Our Ref: AW/146/13/T
Your Ref:

Town & Country Planning Act 1990 (as amended)
Town & Country Planning (Tree Preservation) (England) Regulations 2012
Application for Works to Tree(s) on trees subject to a Tree Preservation Order (TPO)

Development Reduce the crown of 2 No Field Maple trees
Location Ditch to the rear of 23 Fernhurst Gardens Aldwick

SKETCH.

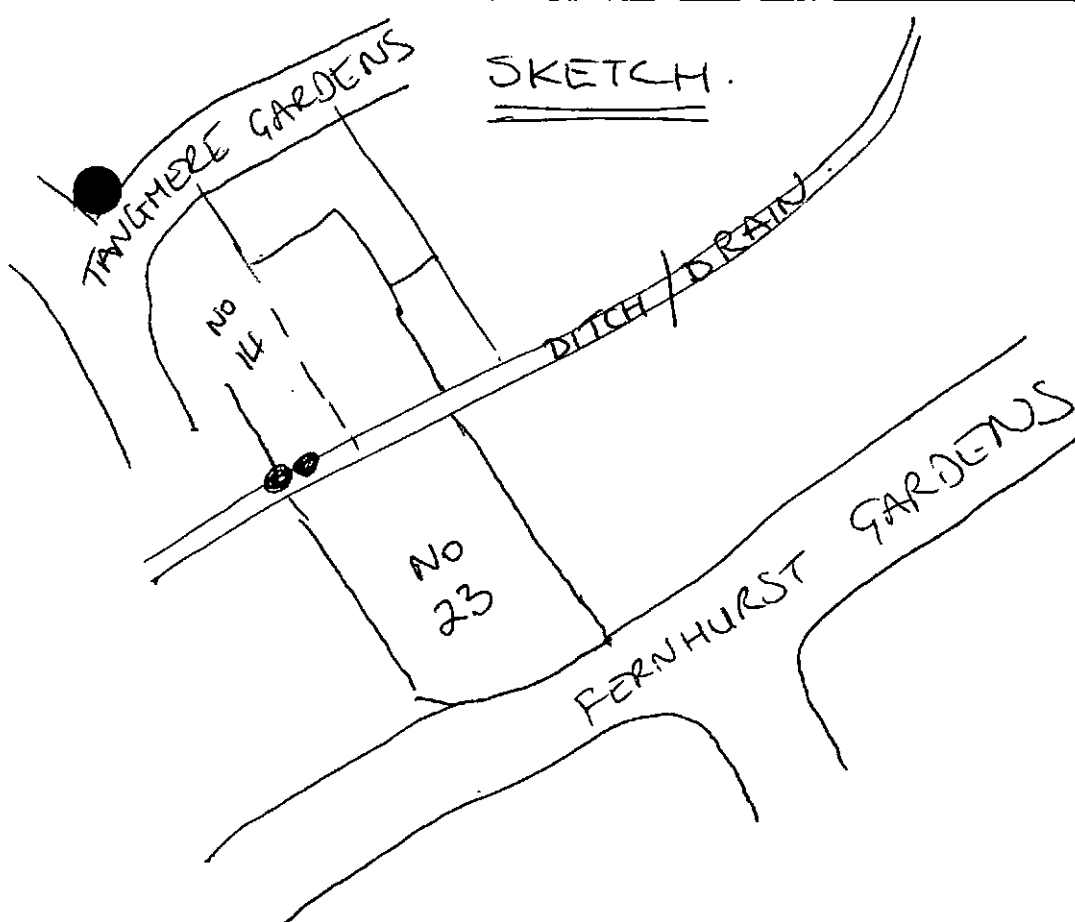
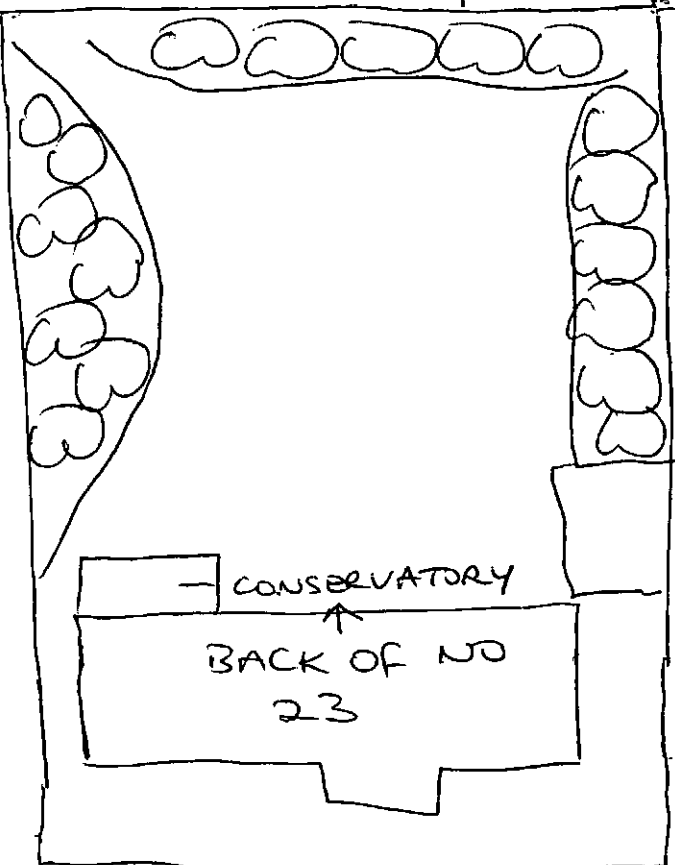
Please provide the measurement, in meters, that you propose to reduce the crowns of the Field Maple trees.
